CITY OF ALBUQUERQUE

July 19, 2018

**Re: Central and Broadway Hotel
Erosion and Sediment Control Plan
Engineer's Stamp Date 7-2-18 (K14E017)**

EROSION AND SEDIMENT CONTROL PLAN

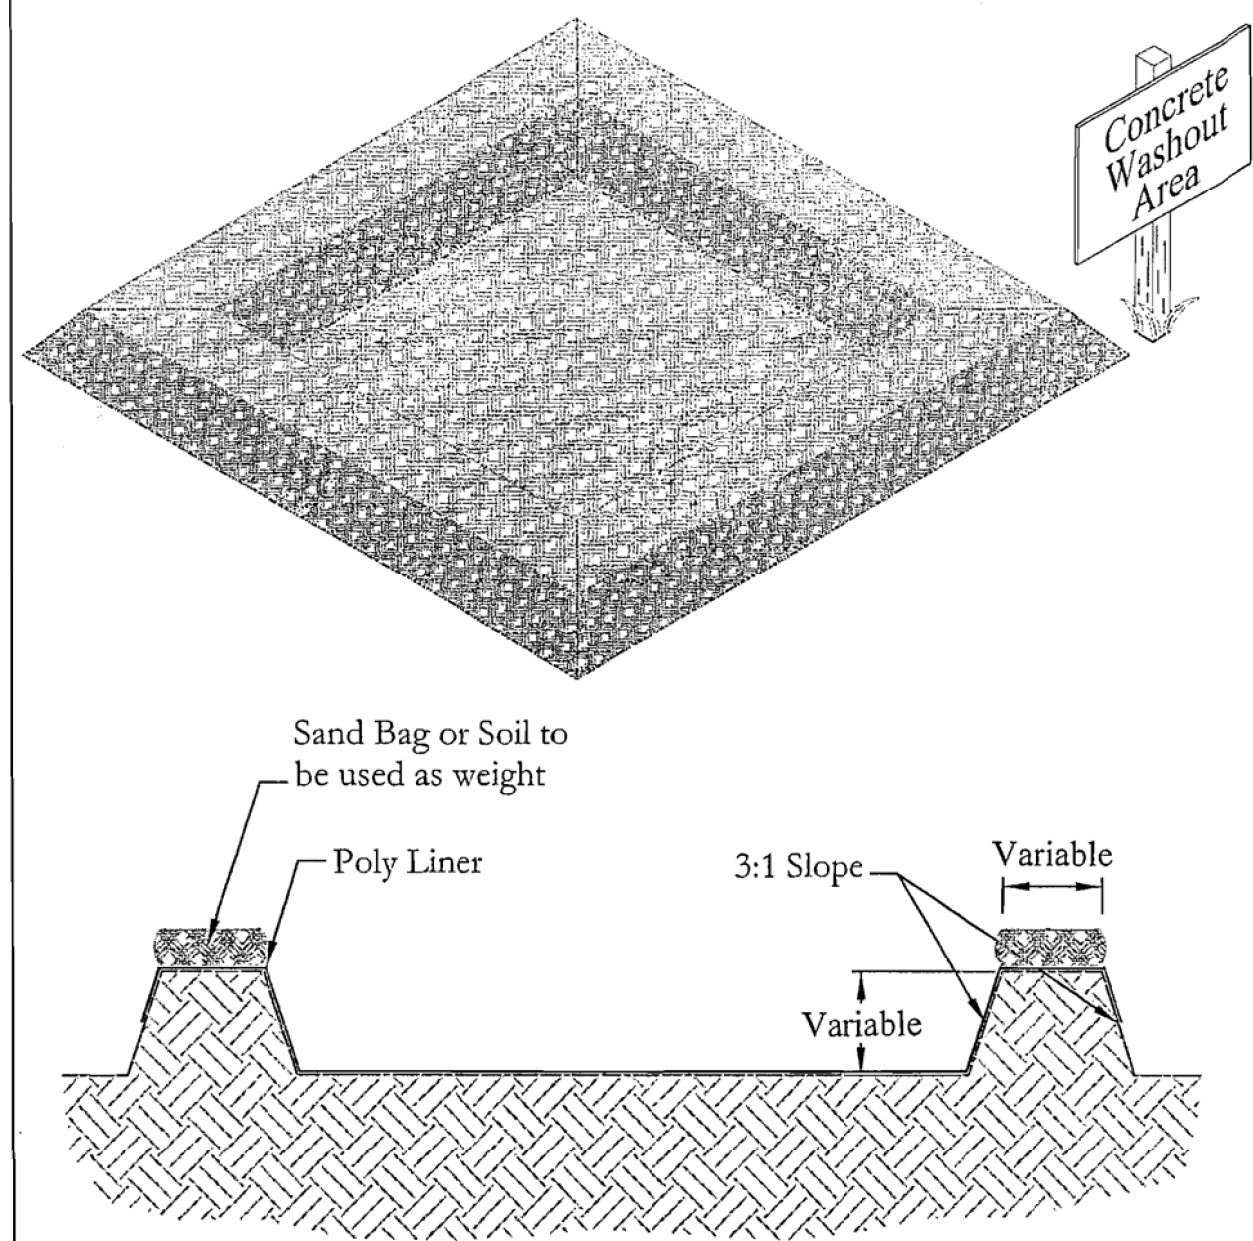
1. The alley between the parking structure is not to be included inside the project boundaries. It is an existing paved City Right of Way. The project should be treated as two sites separated by a street. Proposed sediment BMPs will have to be revised.
2. The stabilized construction is not to be located in the alley at Central Ave. Vehicle tracking control will be needed prior to exiting the site(s) whether it is into the alley or a street.
3. Google street map does not show curb in the NE corner of the site as shown on the plan. There are also gaps in the curb along Central Ave.
4. The legend is designed for color printing, but the plan was submitted in black, gray and white. It is acceptable to submit a black, gray and white plan, but the symbology may have to be adjusted to accommodate the different line types.
